Application No: EP/69/21/PL
Site Address: 4 Beechlands Close and east of 18 Beechlands Court Montpelier Road East Preston BN16 1JZ
Description of works: 1 No. 3-bed bungalow (resubmission following EP/10/21/PL). This site is in CIL Zone 4 & is CIL Liable as new dwelling.

This council's Planning & Licensing Committee considered this Application at its meeting on Monday, 28th June. The committee agreed to object to this Application on the following grounds.

Client	Description
c/o RSP ARCHITECTS LTD	PROPOSED PLANS, ELEVATIONS & SECTION

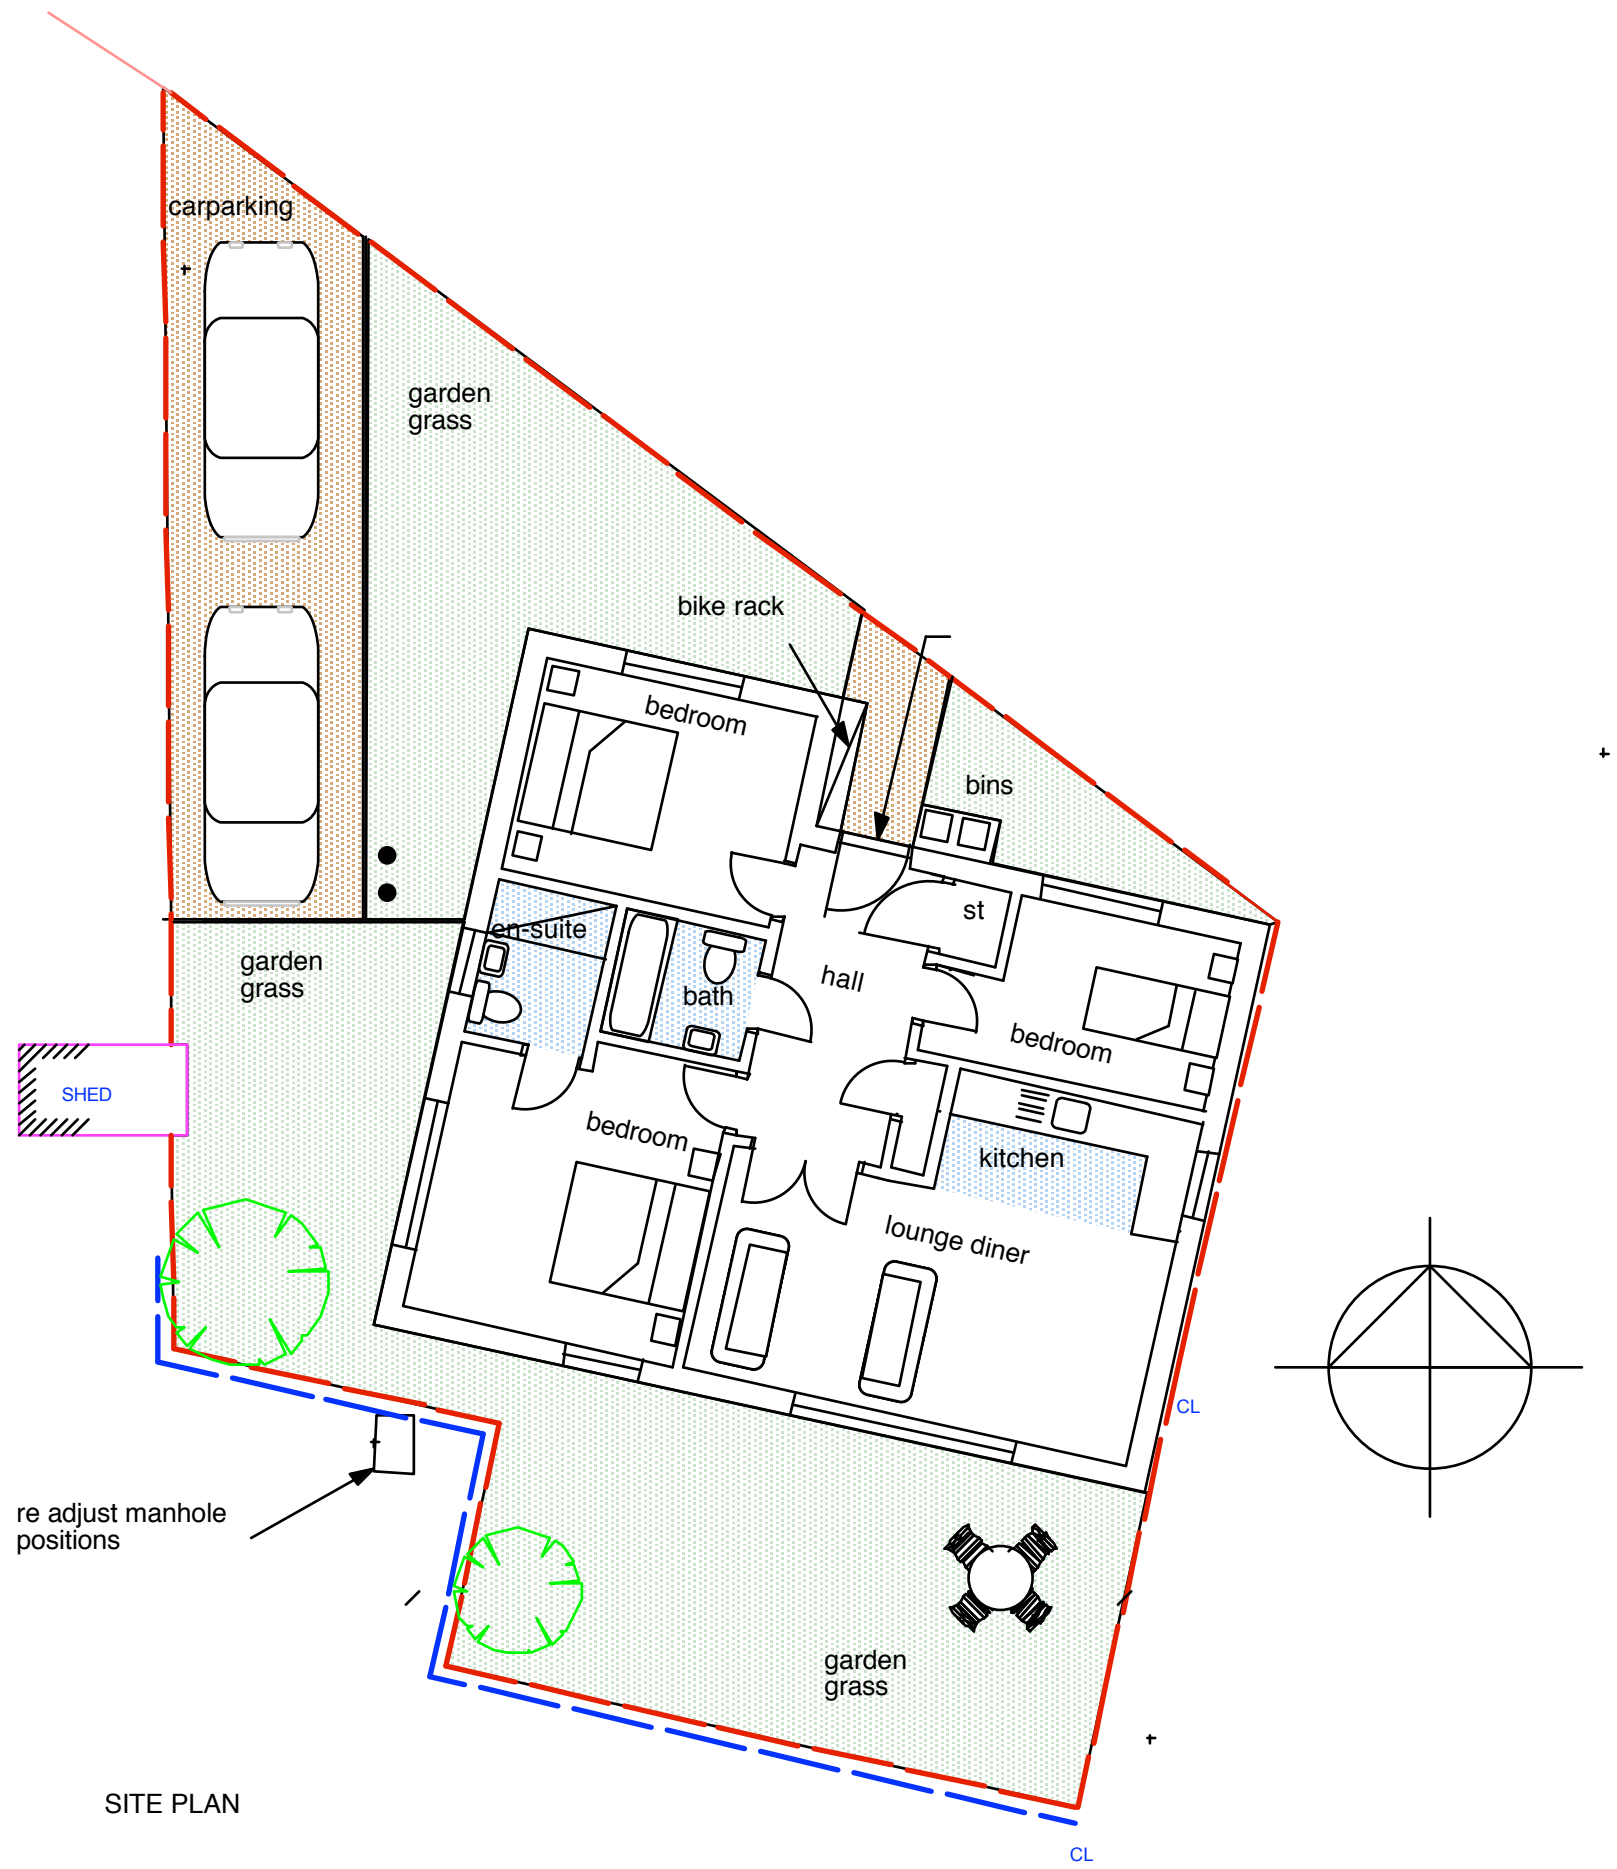
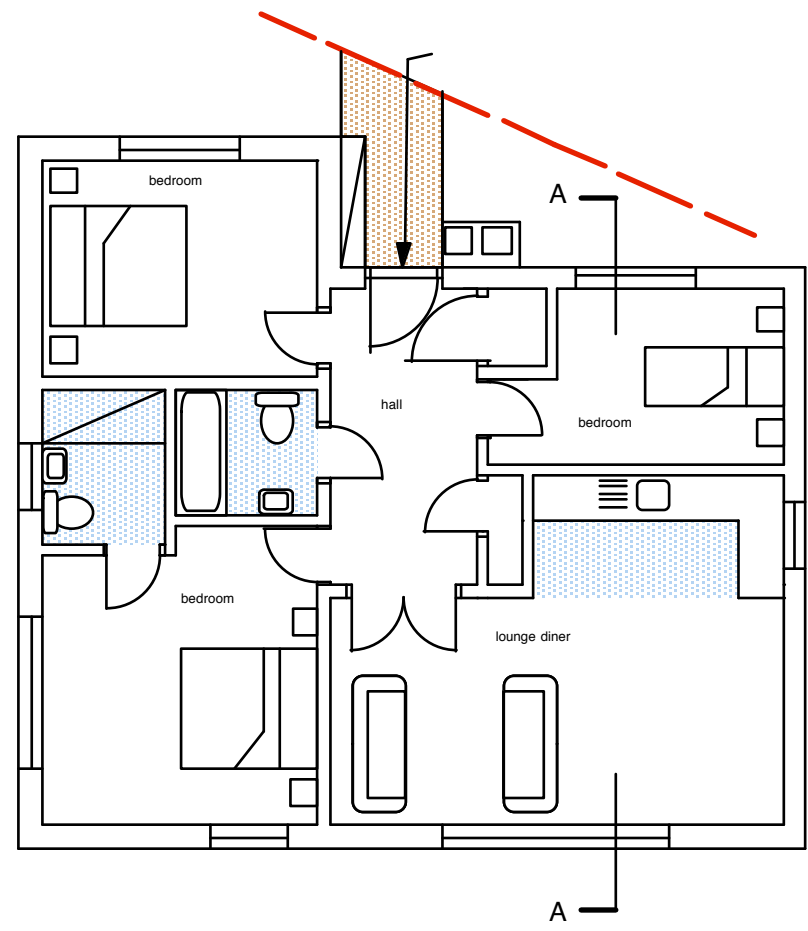
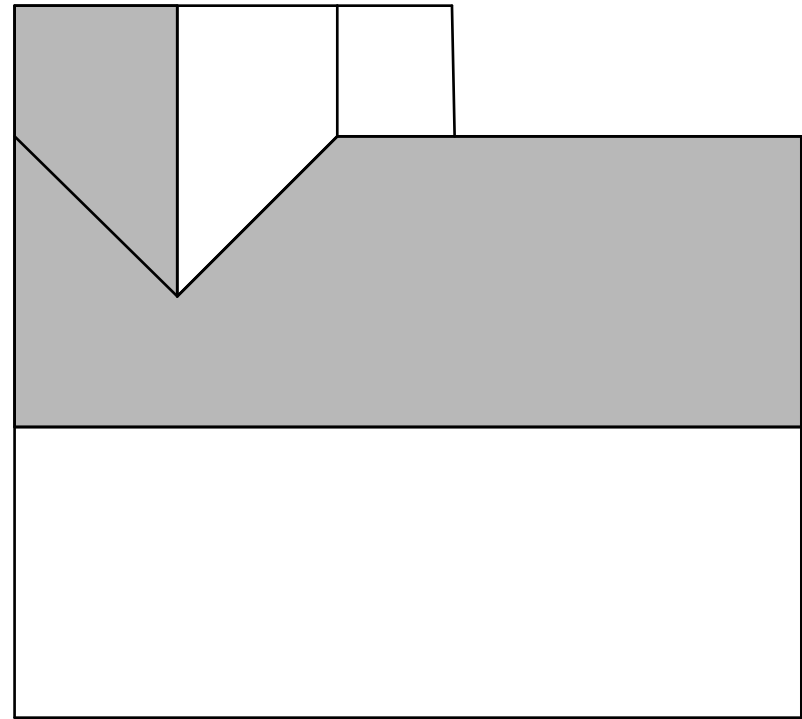
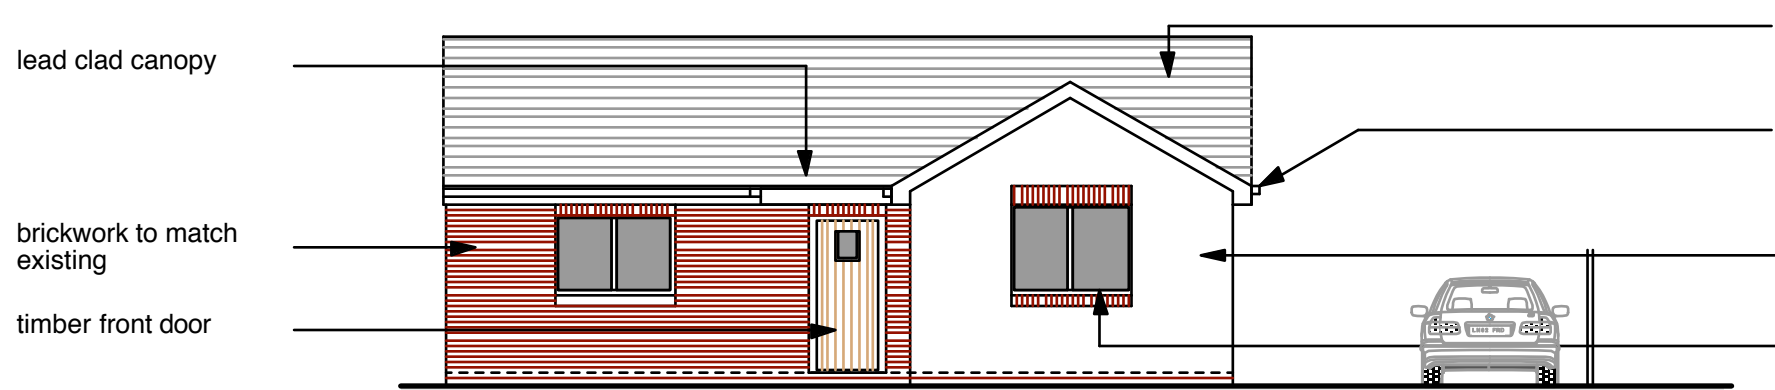
The council is very concerned at the lack of outside amenity space included in this proposal and hopes ADC will ensure all inner and outer dimensions of this proposed building accord with ADC's own amenity standards.

The council remains concerned about the likelihood a property capable of sleeping up to five people will require more than two parking spaces in an area where parking availability is already limited.

In light of the concerns over amenity space provided, should ADC be minded to grant Planning Permission for this property, this council asks that an Article 4 is applied to the property removing Permitted Development rights for the property as any extensions will simply further erode the limited amenity space.
